North West Rail Link (NWRL)

Environmental Impact Statement 2

Opposition to Robert Road being used as an access road into the
Cherrybrook Station Precinct

The application number (SSI-5414)

Figure 6.12 Cherrybrook Station - Indicative vehicle and pedestrian movements

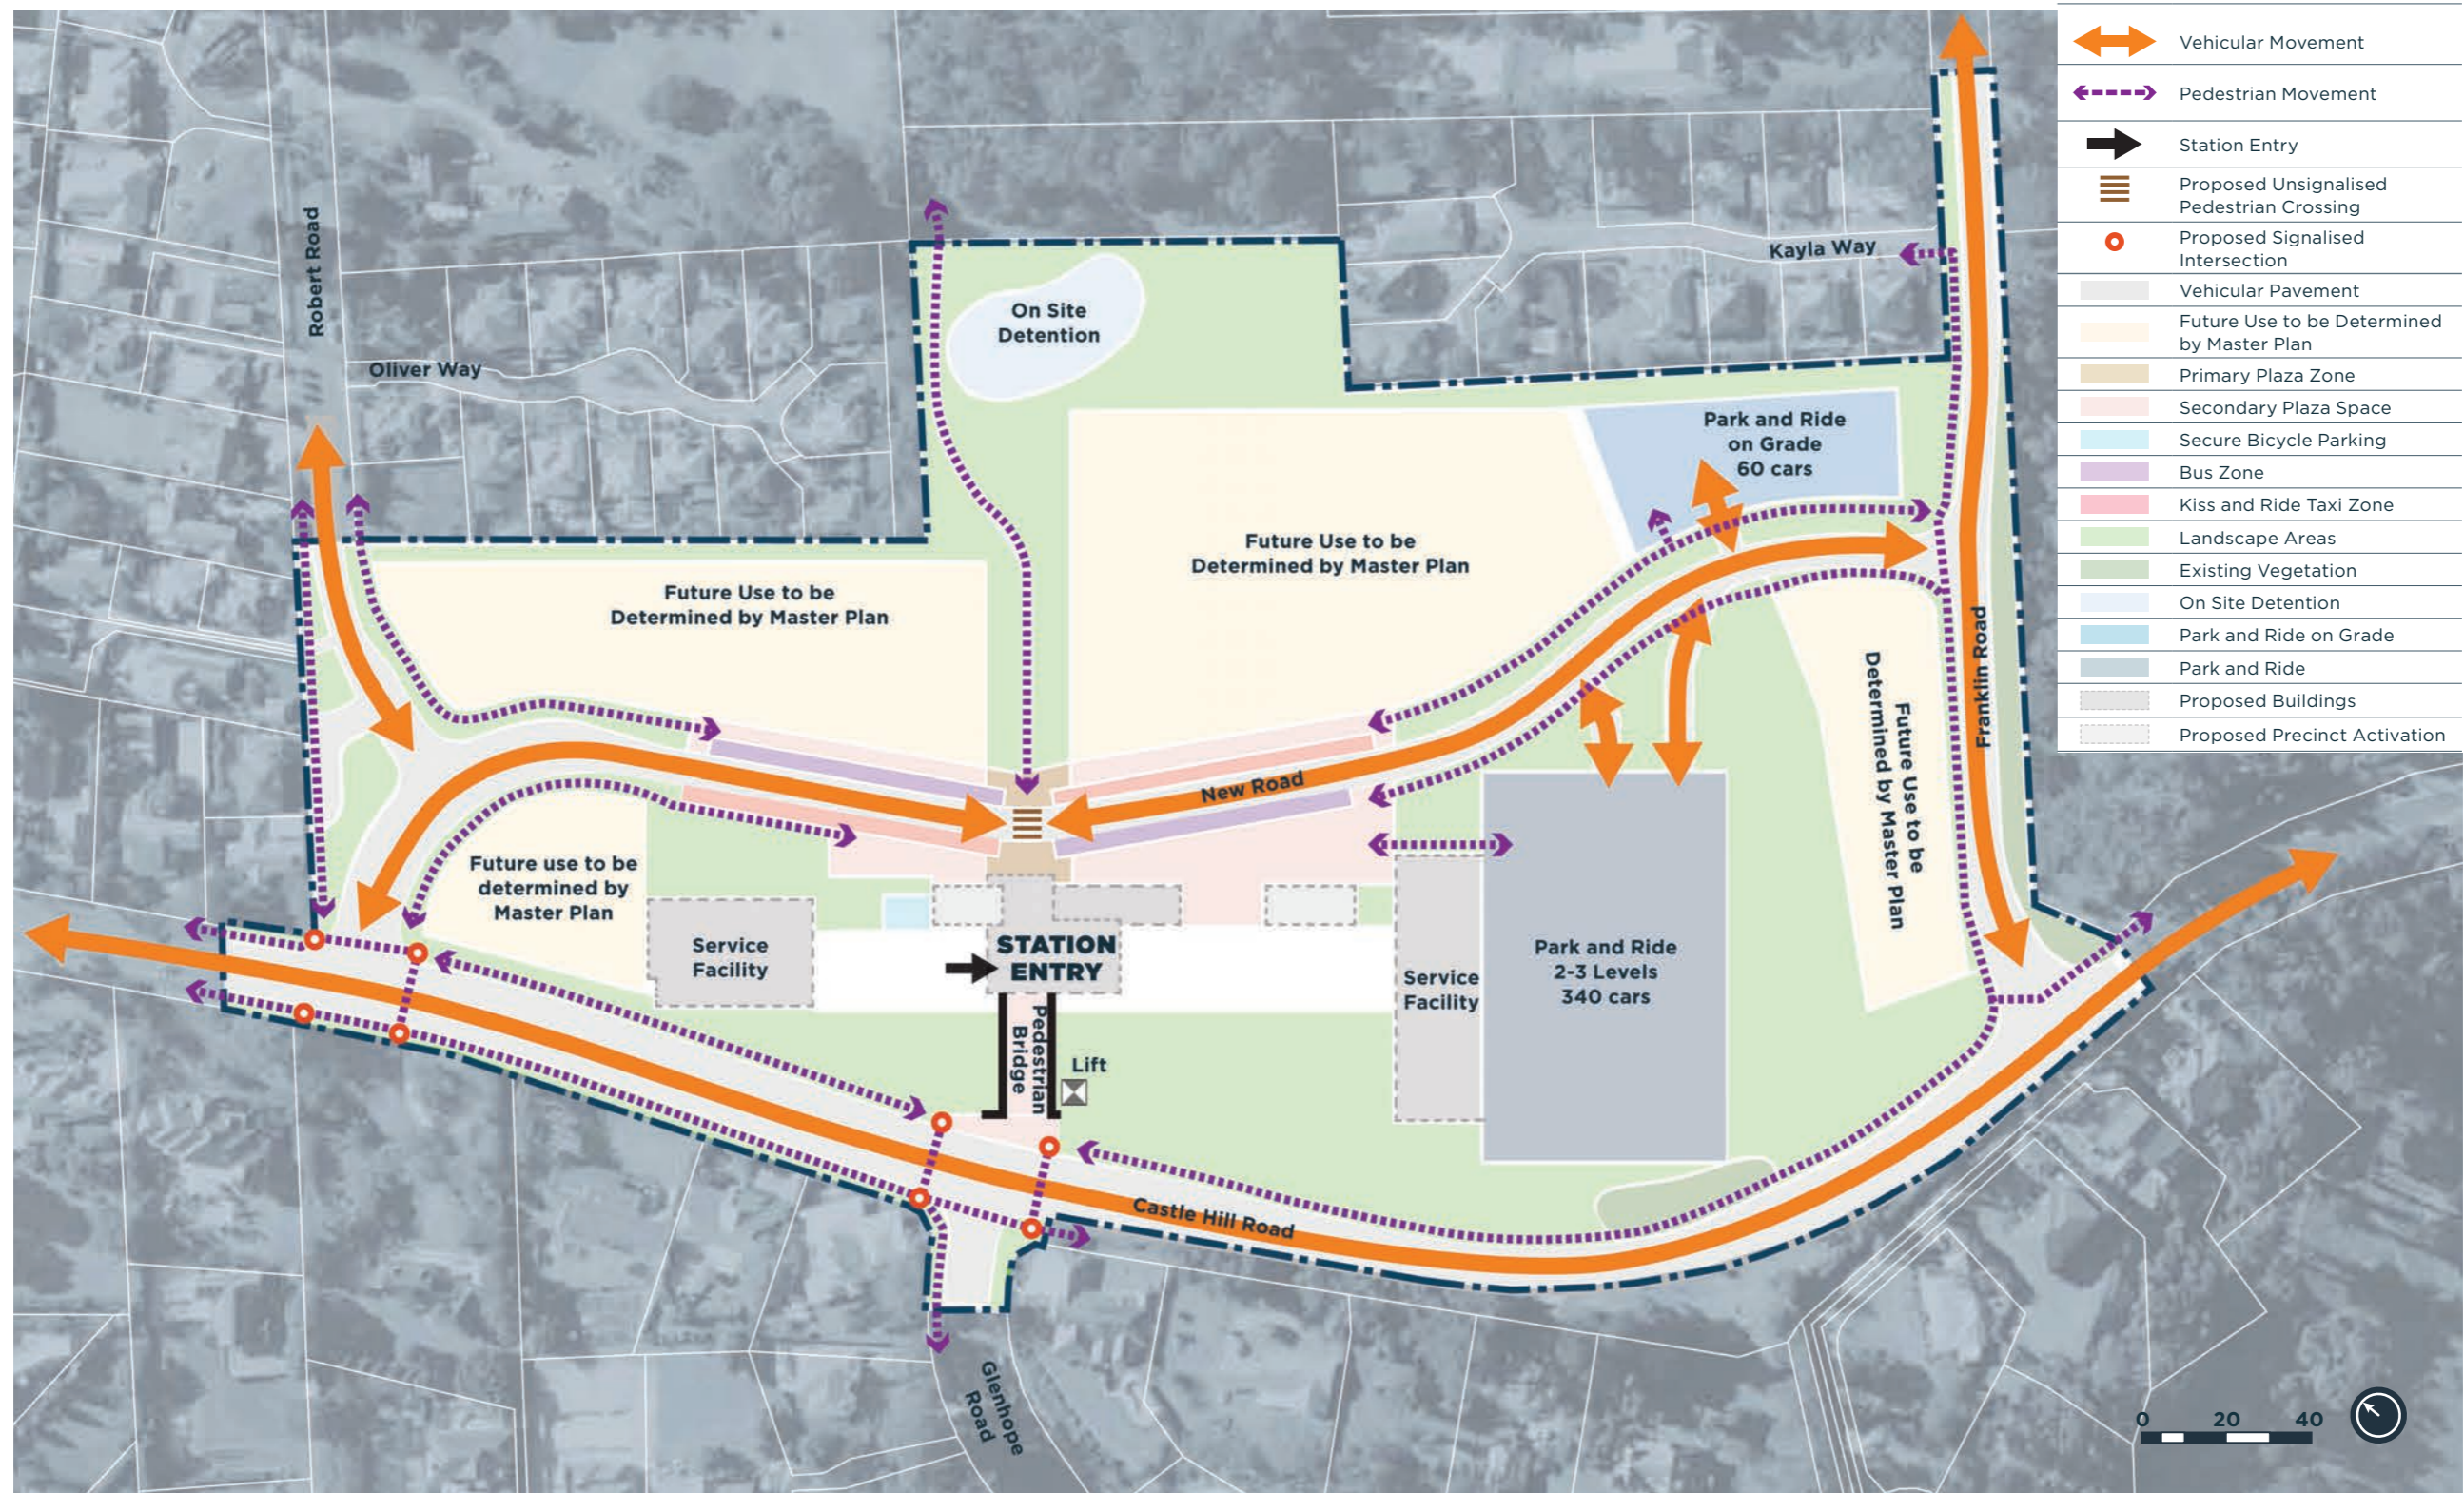
Thank you for the opportunity to respond to NWRL Environmental Impact Statement 2. Although I am in support of the North West Rail Link as a whole, I am opposing the use of Robert Road as a bus and vehicle access road into the station precinct in any capacity.

In conclusion, I am totally perplexed as to why the NWRL would want to squeeze buses up the narrow street of Robert Road when a perfectly sound and underutilised major road network exists. Even the distance via both routes is exactly the same.

There are approximately 265 residences that use Robert Road as an access road out onto the adjoining major roads. Not only will the NWRL be putting the lives of these residents at risk but they will also be turning the quiet neighbourhood street that we have chosen to live in, into a "rat-run" that is not only noisy and busy but will offer no resident or visitor parking.

1. During peak hour times, dedicate the current 'parking lanes' on County Drive between John Road and Castle Hill Road to "Bus Only Lanes" (see Appendix A).

2. Current bus routes should remain the same and a dedicated shuttle service to the station should be introduced.
